Appeal Decision

Appeal Ref: APP/R5510/D/25/3366604

69 Copse Wood Way, Northwood, Hillingdon HA6 2TZ

- The appeal is made under section 78 of the Town and Country Planning Act 1990 (as amended) against a refusal to grant planning permission.
- The appeal is made by Mr. & Mrs. Patel against the decision of the Council of the London Borough of Hillingdon.
- The application Ref is 12231/APP/2025/510.
- The development proposed is described as a “retrospective application for fence”.

EXISTING FENCING ELEVATION
SCALE 1:100

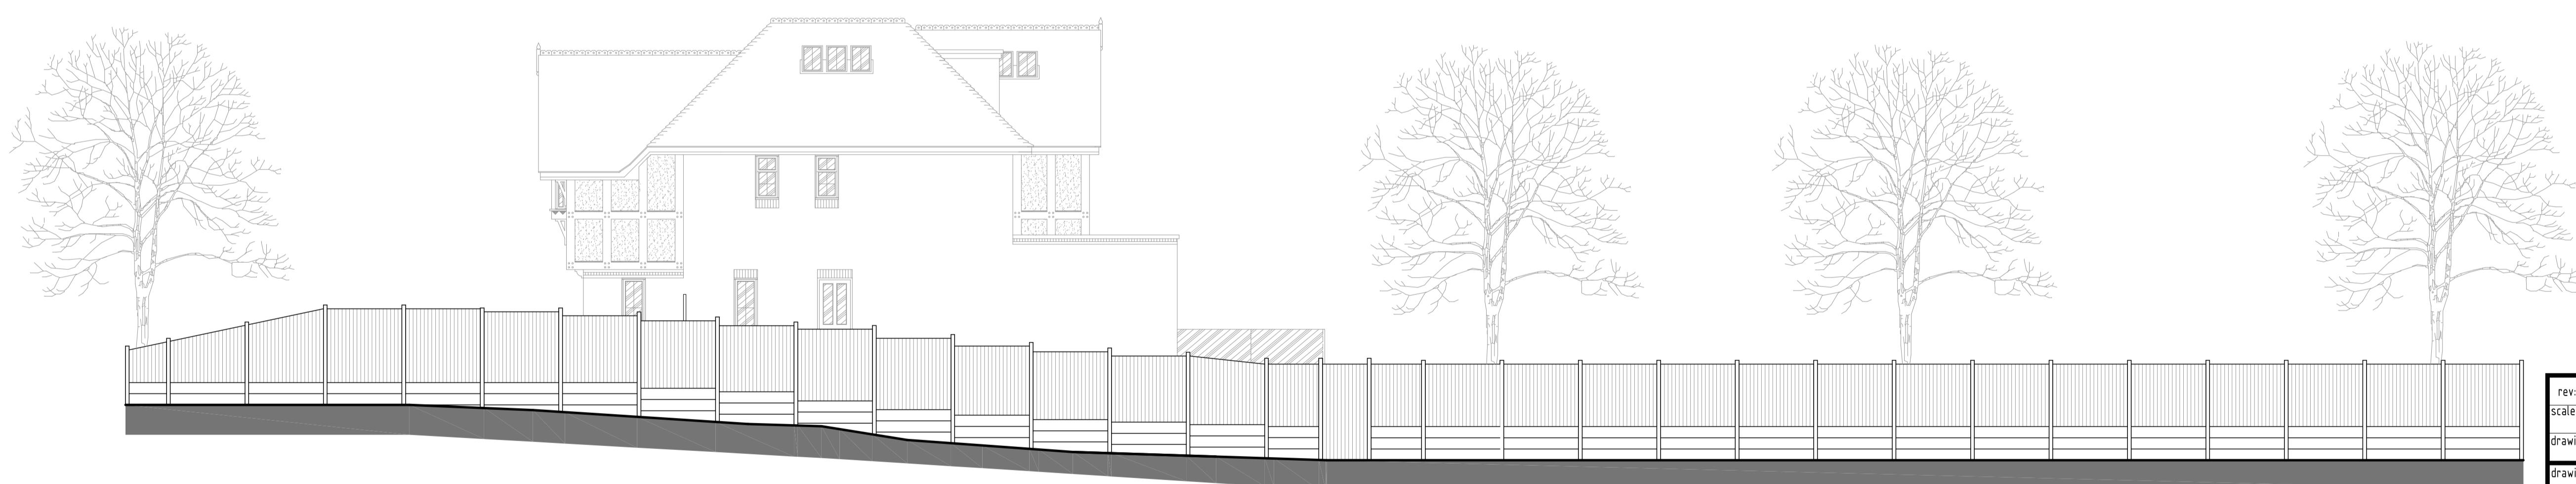
3. The submitted plans show a straight and level fence from the side gate towards the rear boundary. However, the erected version on site features staggered height timber panels. Nonetheless, there is sufficient information available to make an informed assessment of the development from both the plans and what I saw on site. The main issue in regard to which is the effect of the fence on the character and appearance of the area, with specific regard to the Copse Wood Estate Area of Special Local Character (ASLC).

5. The fence is prominently sited along the edge of the public pavement, being of a considerable height and spanning the full side boundary length. It also has light coloured timber panels and high level gravel boards. Whilst these materials are present in the area, it is the development's scale and siting, combined with its

extensive length and bright finish, which appears obtrusive and incongruous to the street scene. Its imposing presence is further pronounced by the site's elevated position. This is a stark contrast from the previous side boundary of a long hedgerow with mature planting and a short section of timber fencing, which evidently supported a more open, landscaped setting.
